From: [REDACTED]
To: [Norfolk Boreas](#)
Subject: Boreas Project EN010087
Date: 05 March 2020 21:39:56
Attachments: [viewpoint3landform2.png](#)
[viewpoint7landform2.png](#)

I would like to comment on some of the applicants answers to the ExA's written questions.

Title:
Noise receptor locations

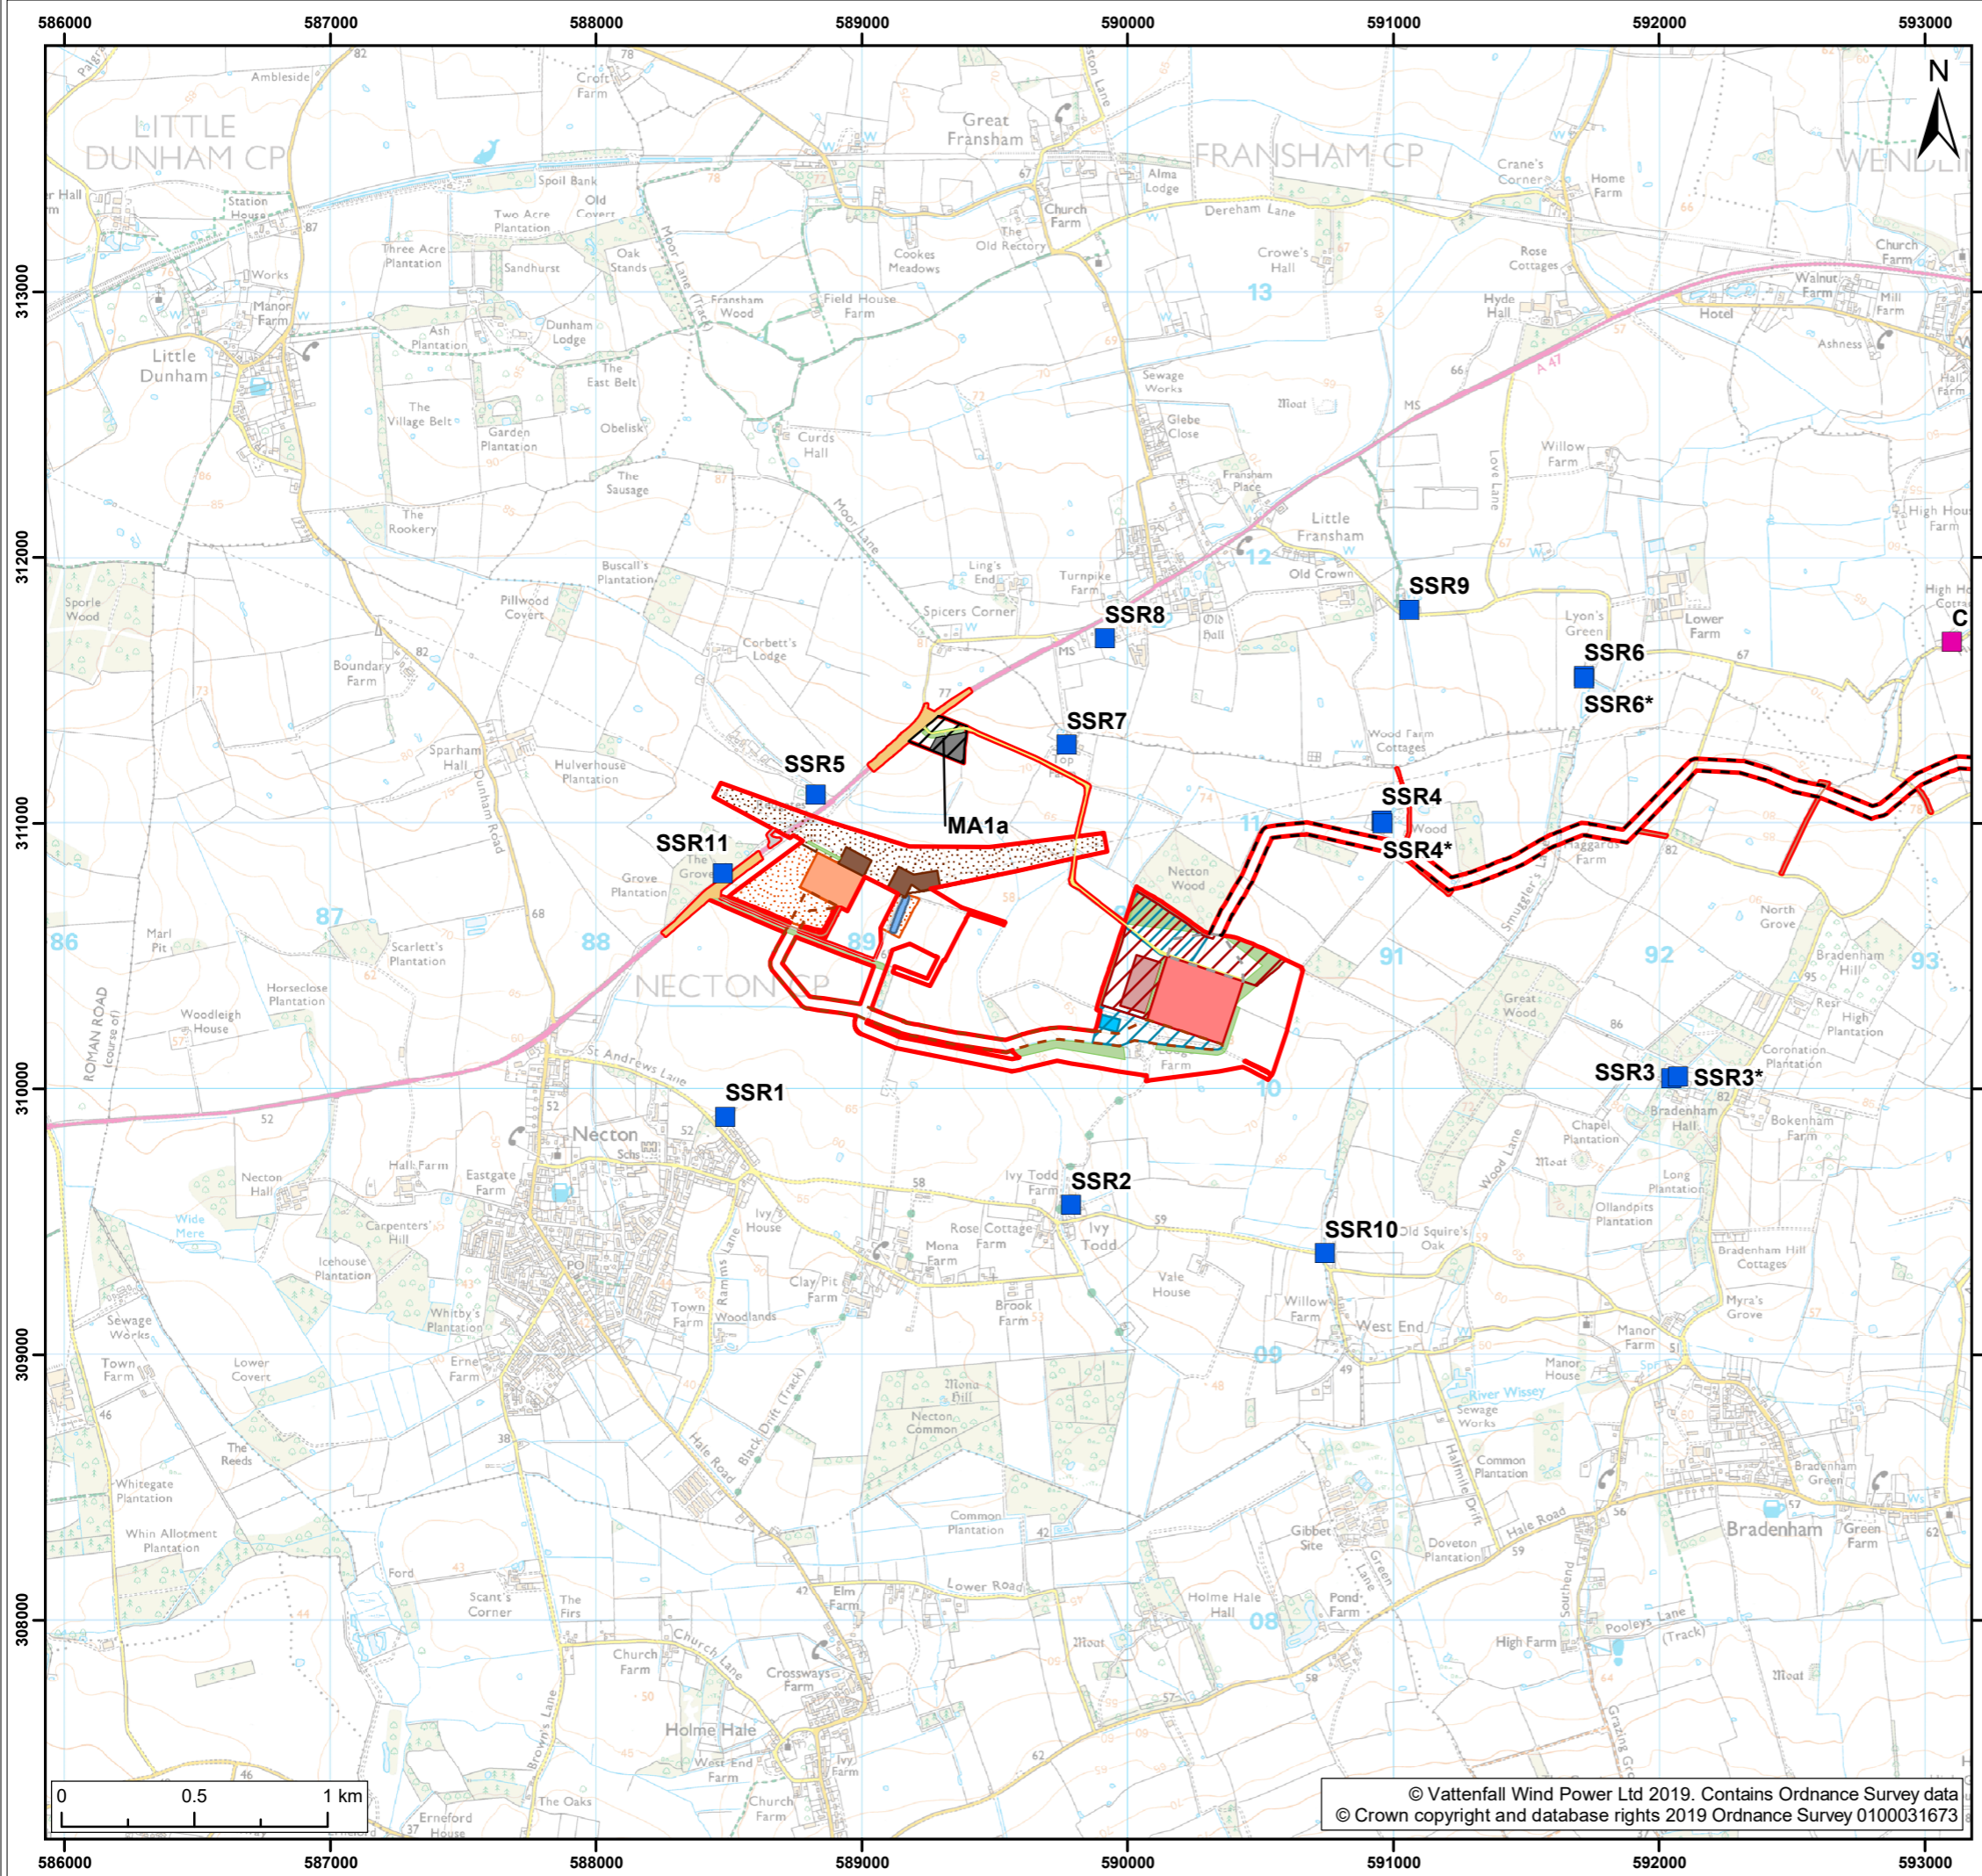
2.12.2.3. The applicant states SSR2 is at Ivy Todd Farm. It is at Lodge Cottage, but it is close enough. I have always been aware that the Ivy Todd Farm house is considered a noise sensitive receptor, but the farm yard and connected land is not. I have requested that our farm yard and land, at 500m from the substation, be regarded as noise sensitive, to maintain the options of farm diversification, which has long been recognized necessary for small farms.

Title:	Scenario 2 Viewpoint 3: Lodge Lane North
--------	------------------------------------------------

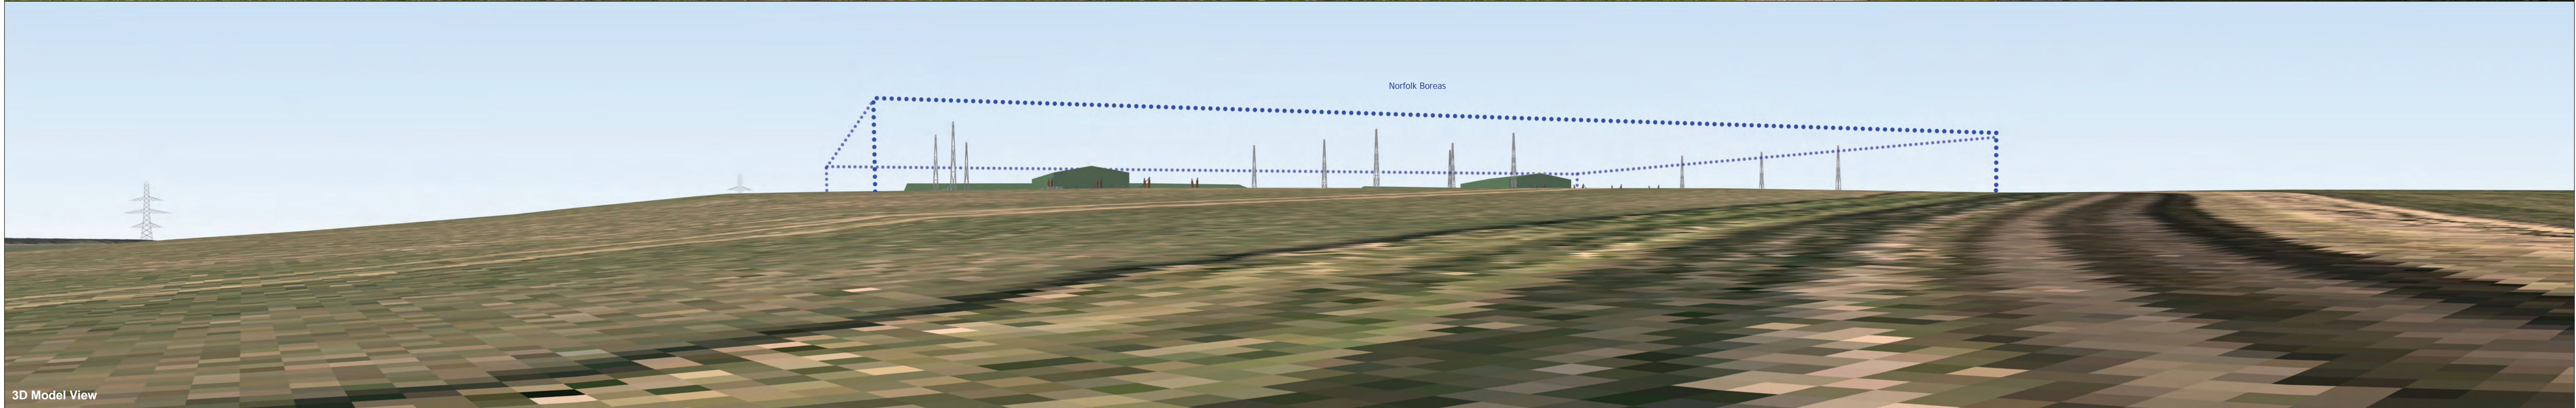
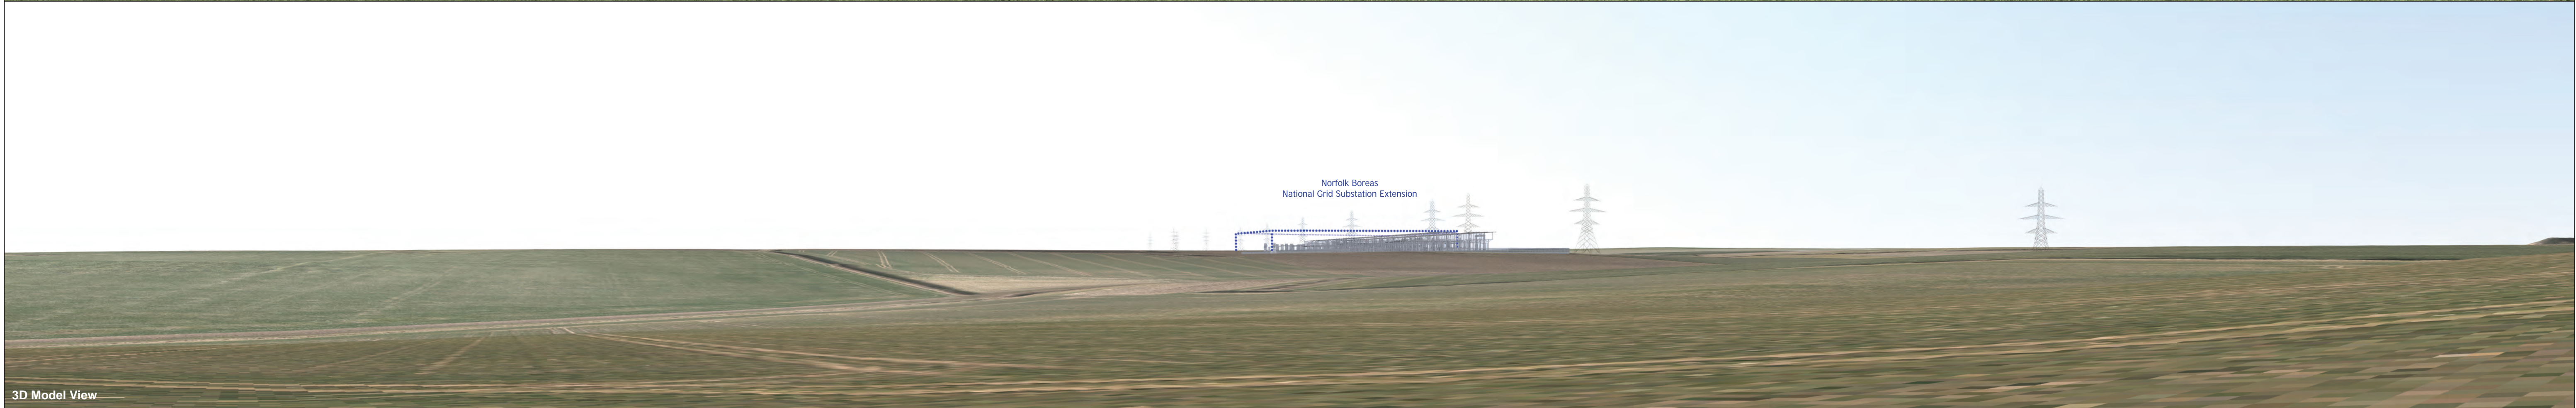
2.9.3.3. I found the cross-sections of the land form provided by the applicant of little use. I have taken the cross-section diagrams and added a 19m converter hall, a level ground, line of view, a viewpoint at 1.5m, and mitigating trees where applicable, using the appropriate scales. This again shows a discrepancy when compared to the photo montages.

After completing the diagrams, which again appeared different to what I expected, I realised they are not drawn to scale. The applicant used one rate of scale for distance, and another for the height. The result is a diagram compressed in length, and overly high. This makes the line of view falsely steep, and the point it intersects the hall unrealistically high. If the diagram had been prepared in scale, it would be much longer, the line of view much shallower, and most of the converter hall would be visible, as I have always suspected. As these cross-sections are another poor tool, it would seem the applicant does not consider mitigating the Necton substation properly, a serious consideration.
